**Oakdale West Estate Stage 3 Development (SSD-9794683)  
Request for additional information**

## **Attachment 1 Department's Comments on the RtS**

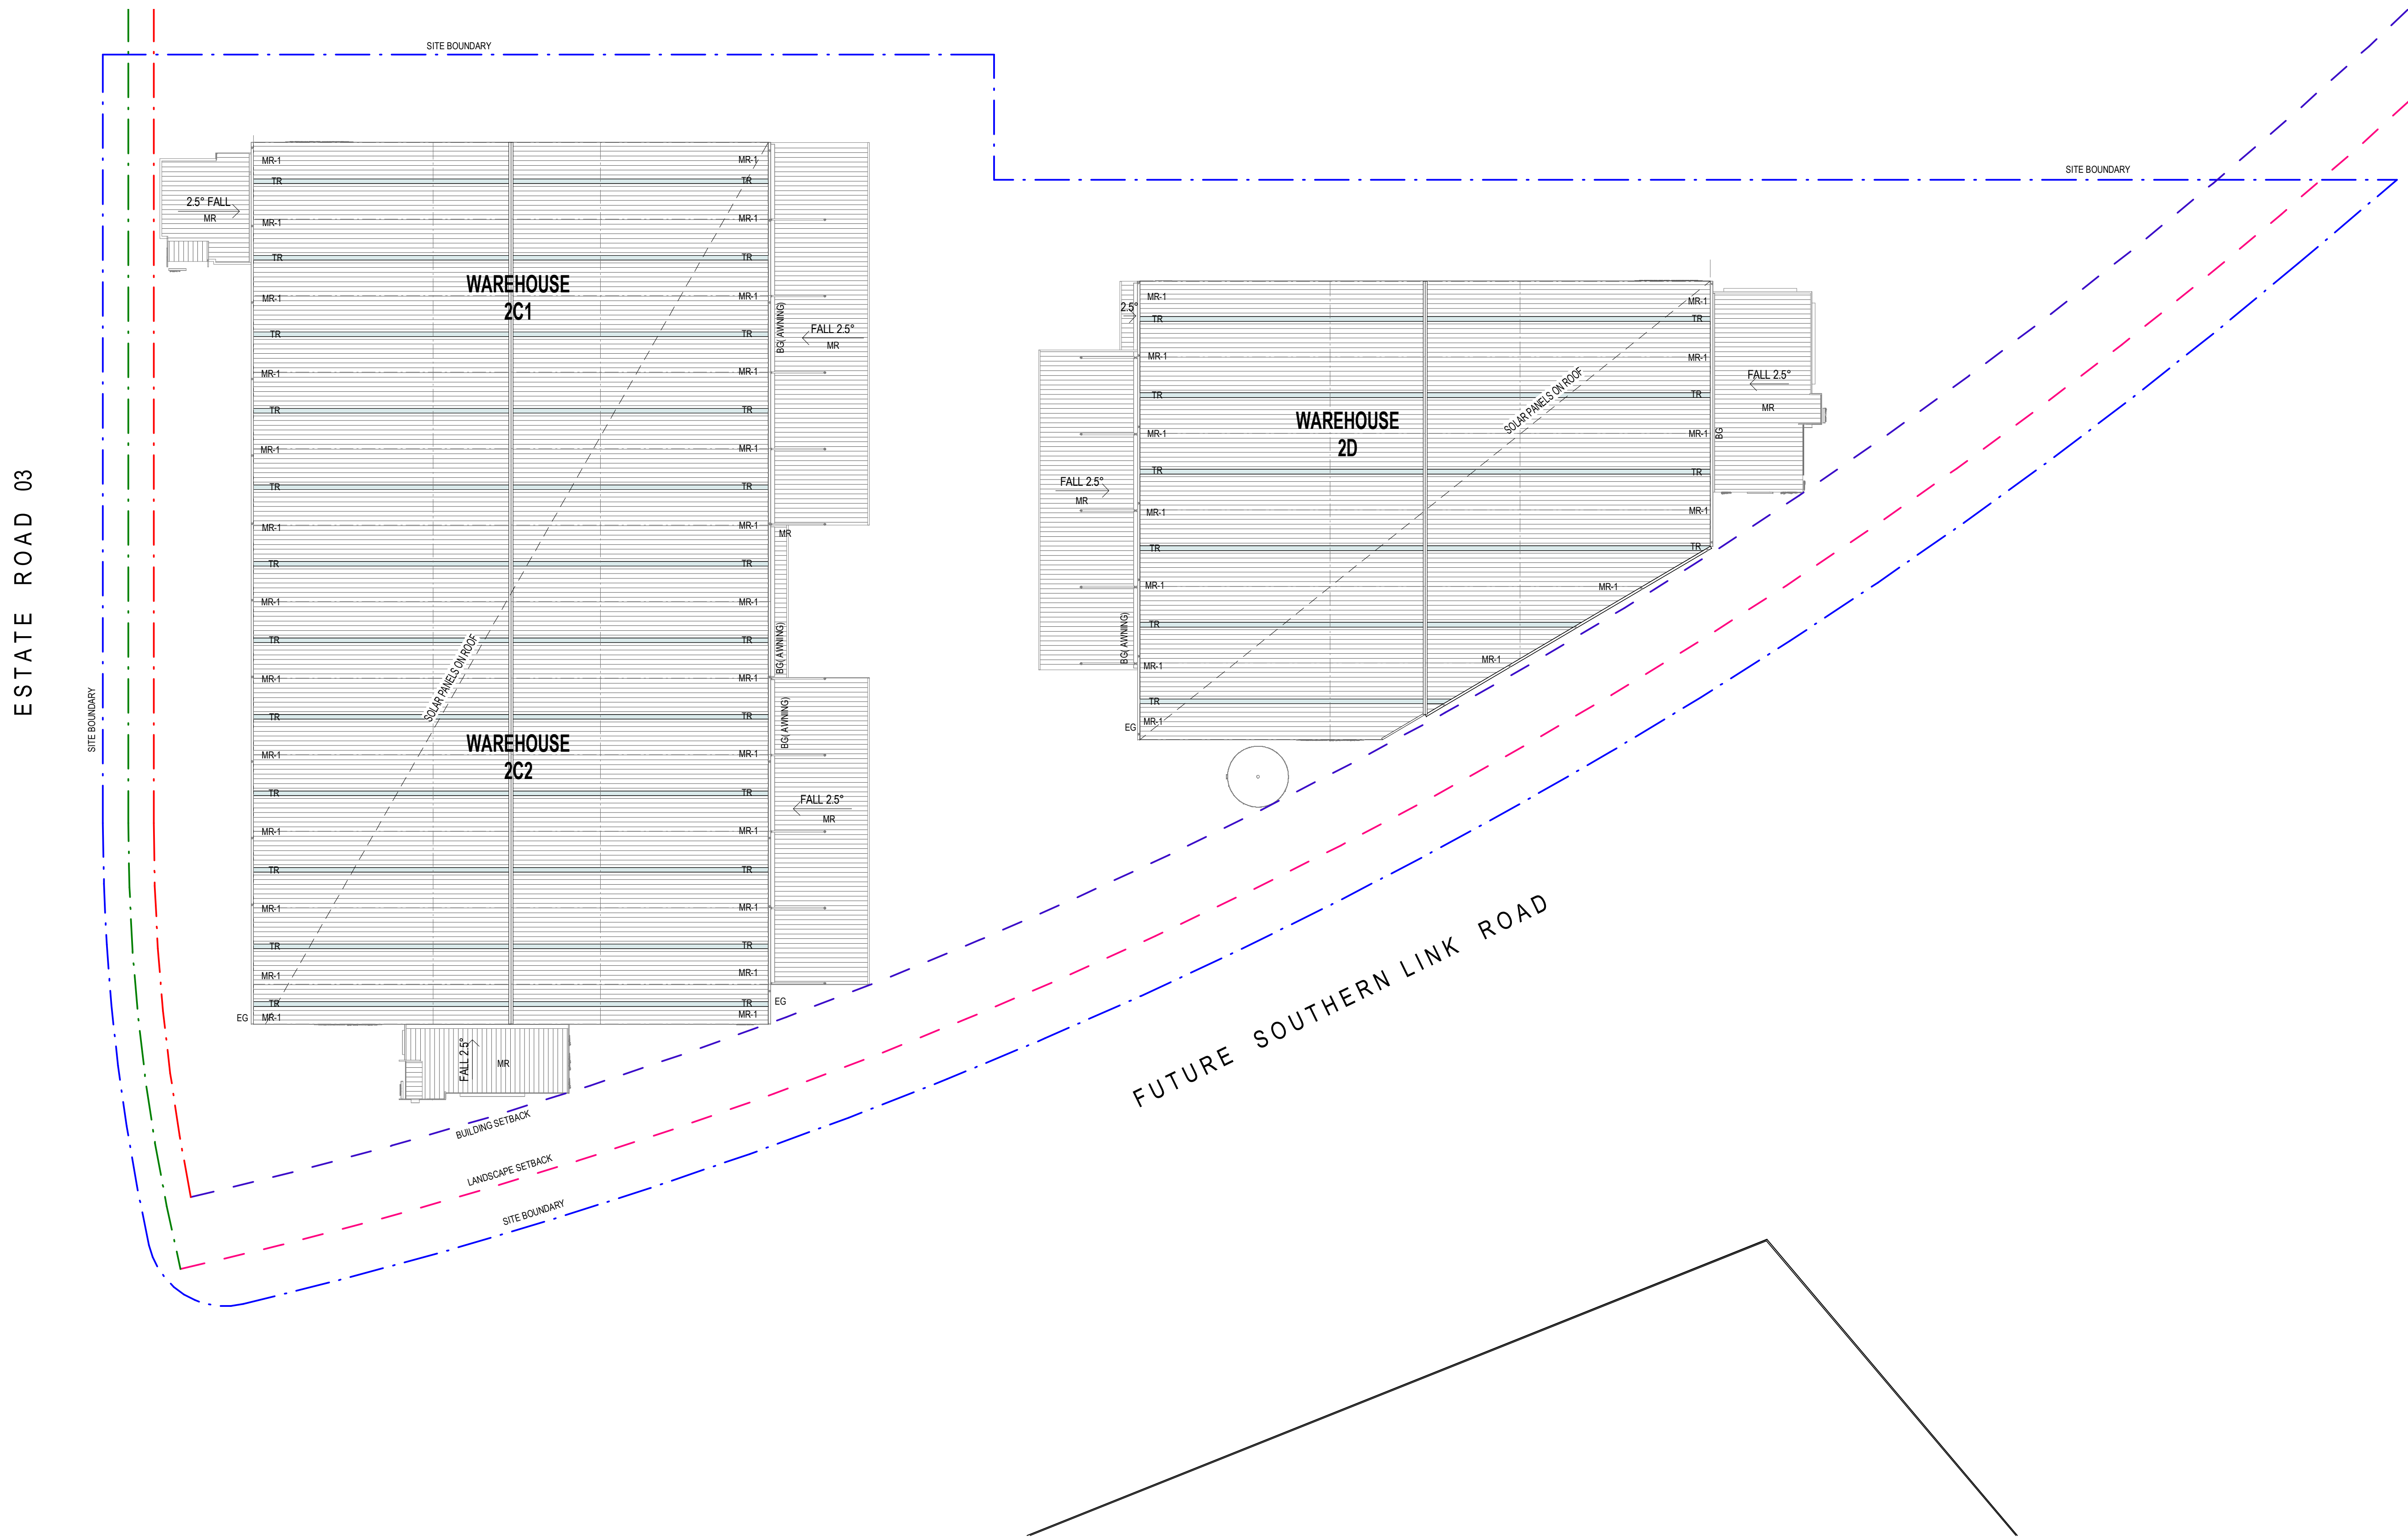
The Department notes that Building 2D would have a shared driveway for light and heavy vehicles, which raises concerns about traffic safety and manoeuvrability. Please provide justification for proposing a shared driveway and details of appropriate mitigation measures including, but not limited to, traffic control devices.

1 ELEVATION WEST - WAREHOUSE 2C 1 : 250

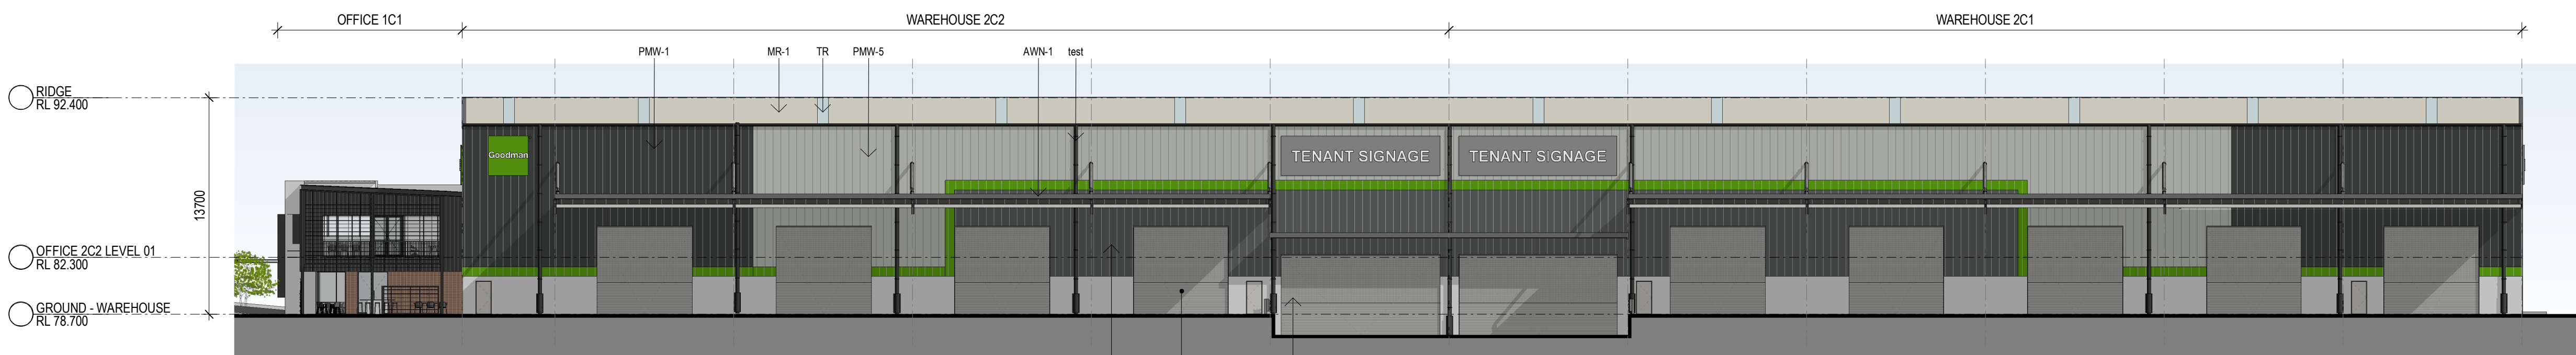
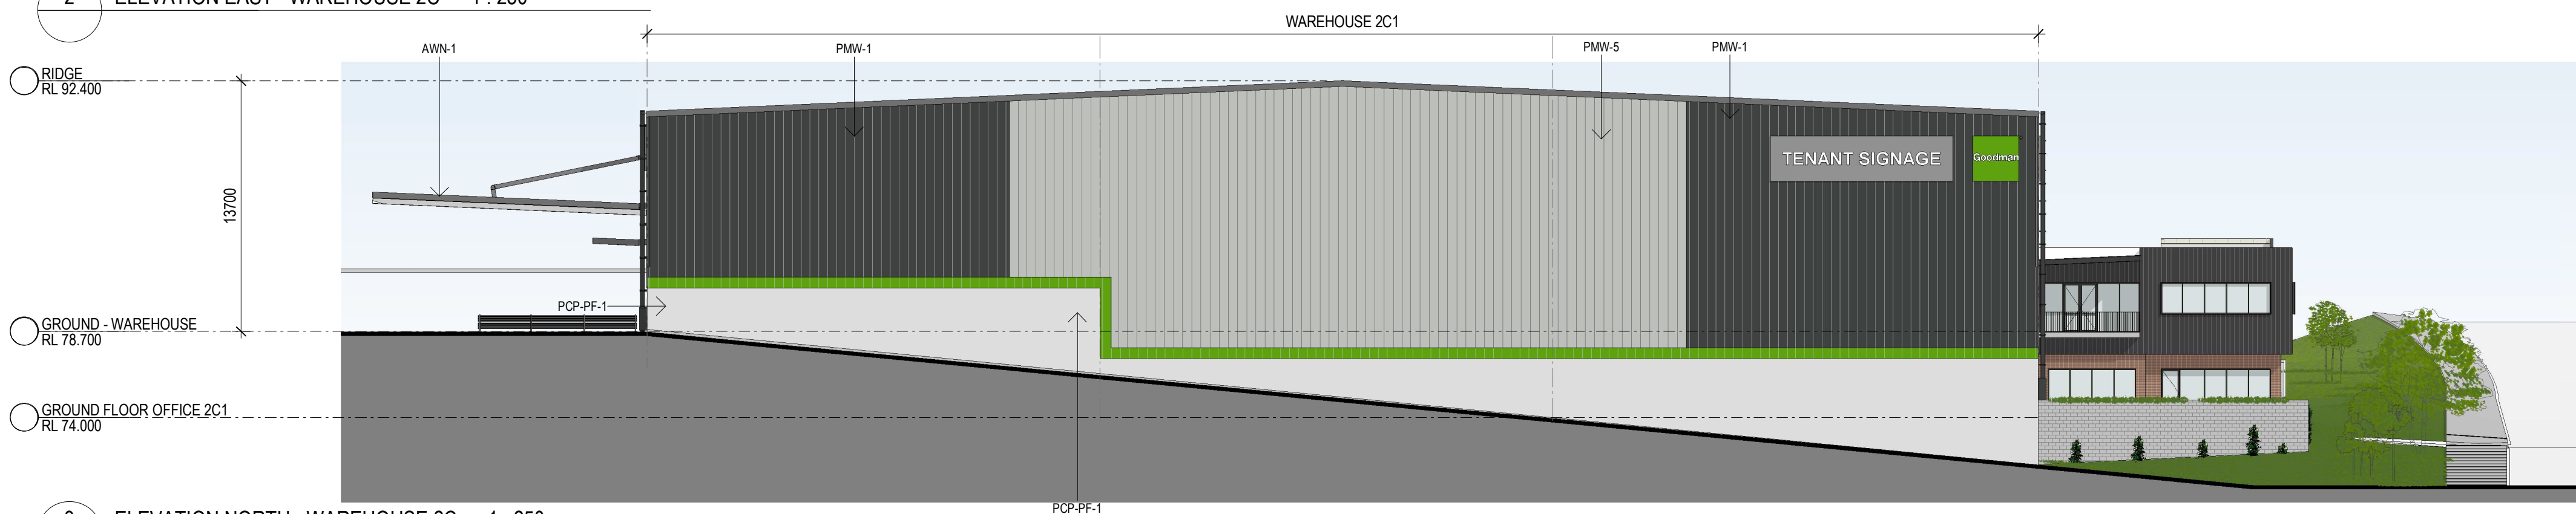
The Department notes that the effective height of Building 2C is approximately 22.2 m, which exceeds the 15 m limit in the Oakdale West Estate Development Control Plan (OWEDCP). Please provide justification for the non-compliance or amend the building design to achieve compliance with the OWEDCP.
